STORMWATER AUDIT (STAGE 1)

JBA Project Code 2019s1152
Contract Residential Development at Farrankelly, Delgany, Co. Wicklow
Client Cairn Homes
Date 18th September 2019 – P01
Author Leanne Leonard
Subject **Stormwater Audit - Stage 1 Report**

Appendix A – Audit Trail Record

Drawing Title: **PROPOSED DRAINAGE LAYOUT SHEET 1**

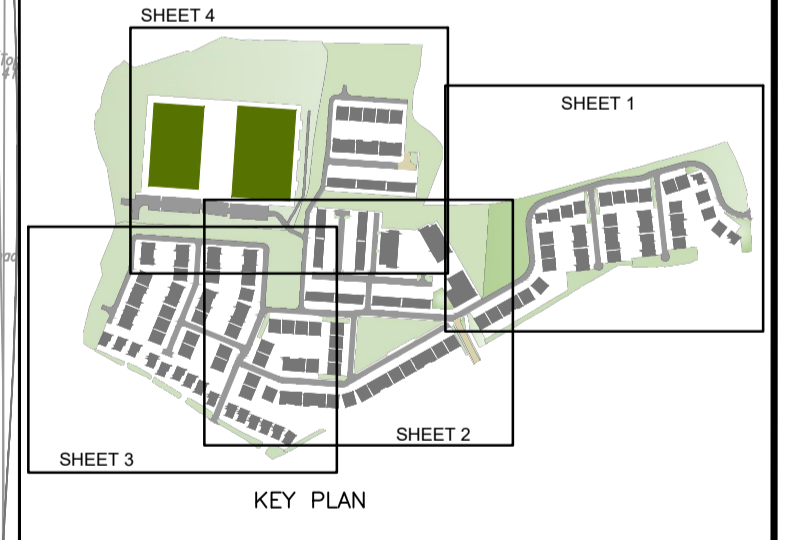
| Item No. | JBA Review Comment | Comment/Clarification Request/Suggested Mitigation | Response from Client/Client Representative | Acceptable / Not Acceptable |
|---------------------|---|--|---|-----------------------------|
| 8 | <p><u>Level of service</u></p> <p>Criterion 3 in Table 6.3 of the GSDSDS states that floor levels should be at least 500mm above maximum river level and adjacent on-site storage retention. Details such as ground level, invert level and top water level have not been provided for the attenuation structures.</p> | At detailed design stage ROD to ensure that all finished floor levels are at least 500mm above maximum river levels and the top water levels of adjacent attenuation structures. | <p>We confirm that the finished floor levels are a minimum of 500mm above the top of water levels in all adjacent attenuation tanks. This is being added to the drawings for clarity.</p> | Acceptable |
| 9 | <p><u>Car-Parking</u></p> <p>It appears that the western most carpark has uncontrolled flows to the outfall pipe</p> | ROD to review. | <p>No flow control device has been provided from the car parking to the pitches as this is captured in the attenuation tank to the north-east. In addition, much of the car park has been designed as grass-crete to reduce the overall flows from this area.</p> | Acceptable |

Client	CAIRN HOMES
Project Title	PROPOSED HOUSING DEVELOPMENT AT FARRANKELLY, WICKLOW
Drawing Title	PROPOSED DRAINAGE LAYOUT SHEET 3
Drawing Number	FK-ROD-20-XX-DR-C-0033
Scale	1:500
Date	SEPT 19
Job No.	16146
Cad File	J:\2016\16146\DWG

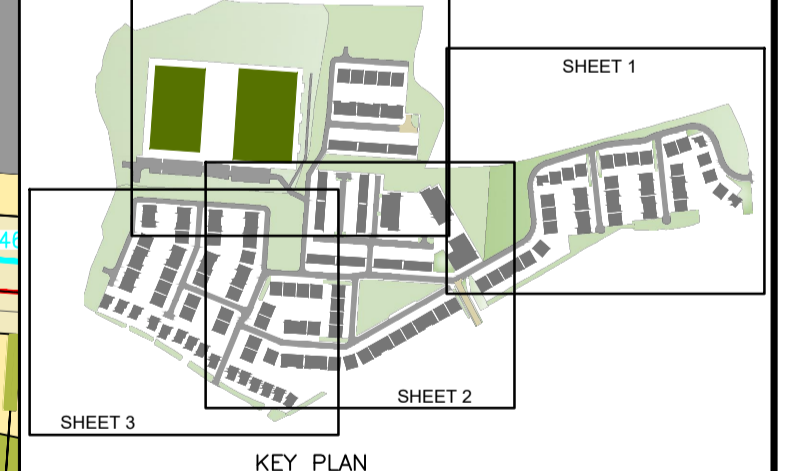
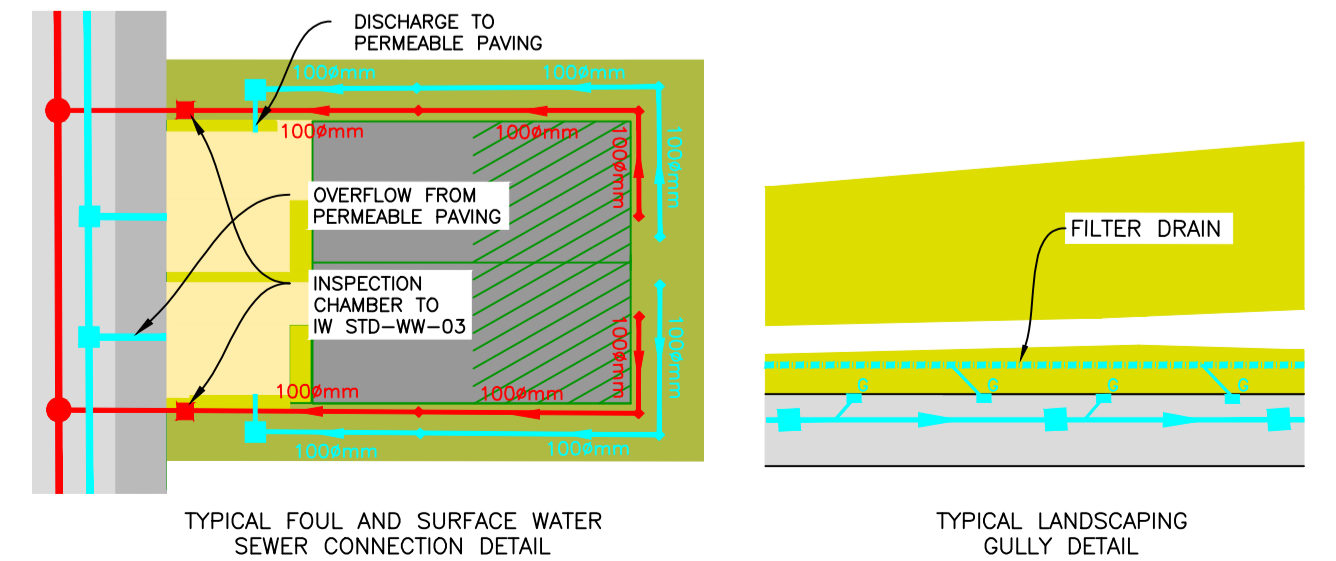
| Item No. | JBA Review Comment | Comment/Clarification Request/Suggested Mitigation | Response from Client/Client Representative | Acceptable / Not Acceptable |
|---------------------|---|--|---|-----------------------------|
| 5 | <p><u>SuDS treatment train</u></p> <p>From the drawings and Engineering Report provided it is not clear if the treatment train has been addressed sufficiently.</p> <p>We note that the Engineering Report lists attenuation tanks, permeable paving and soakaways as the SuDS measures included in the design.</p> <p>Although permeable paving has been provided for car parking spaces and driveways within the site it's not clear if these will discharge back to the main surface water system.</p> <p>As the soakaways haven't been identified on the drawings it's not clear what is contributing to them and whether an overflow back to the SW network will be provided.</p> | ROD to clarify. | <p>The references to soakaways is an error and has been removed from the report. This is due to the fact that despite suitable ground tests on the neighbouring development, soakaways did not work as designed and resulted in remedial works. Instead, the suds measures include for the permeable paving (through which roof drainage will also flow), gullies discharging to tree pits, and permeable attenuation tanks to discharge to ground and take advantage of whatever recharge is available. The final discharge is also run through petrol interceptors as per the drawings.</p> | Acceptable |
| 6 | <p><u>Interception</u></p> <p>Further to point 6 above it's not clear if the first 5mm of rainfall has been intercepted.</p> | ROD to clarify. | <p>The Engineering report has been updated to include for road gullies to discharge to tree-pits around the green-open spaces. There are also a number of pipes that can be constructed as filter drains allowing the first 5mm of run-off to be contained within the site, which has also been noted within the report and drawings. When combined with the permeable nature of the attenuation tanks, we are of the opinion that this results in the first flush of rainfall being intercepted and contained within the site.</p> | Acceptable |
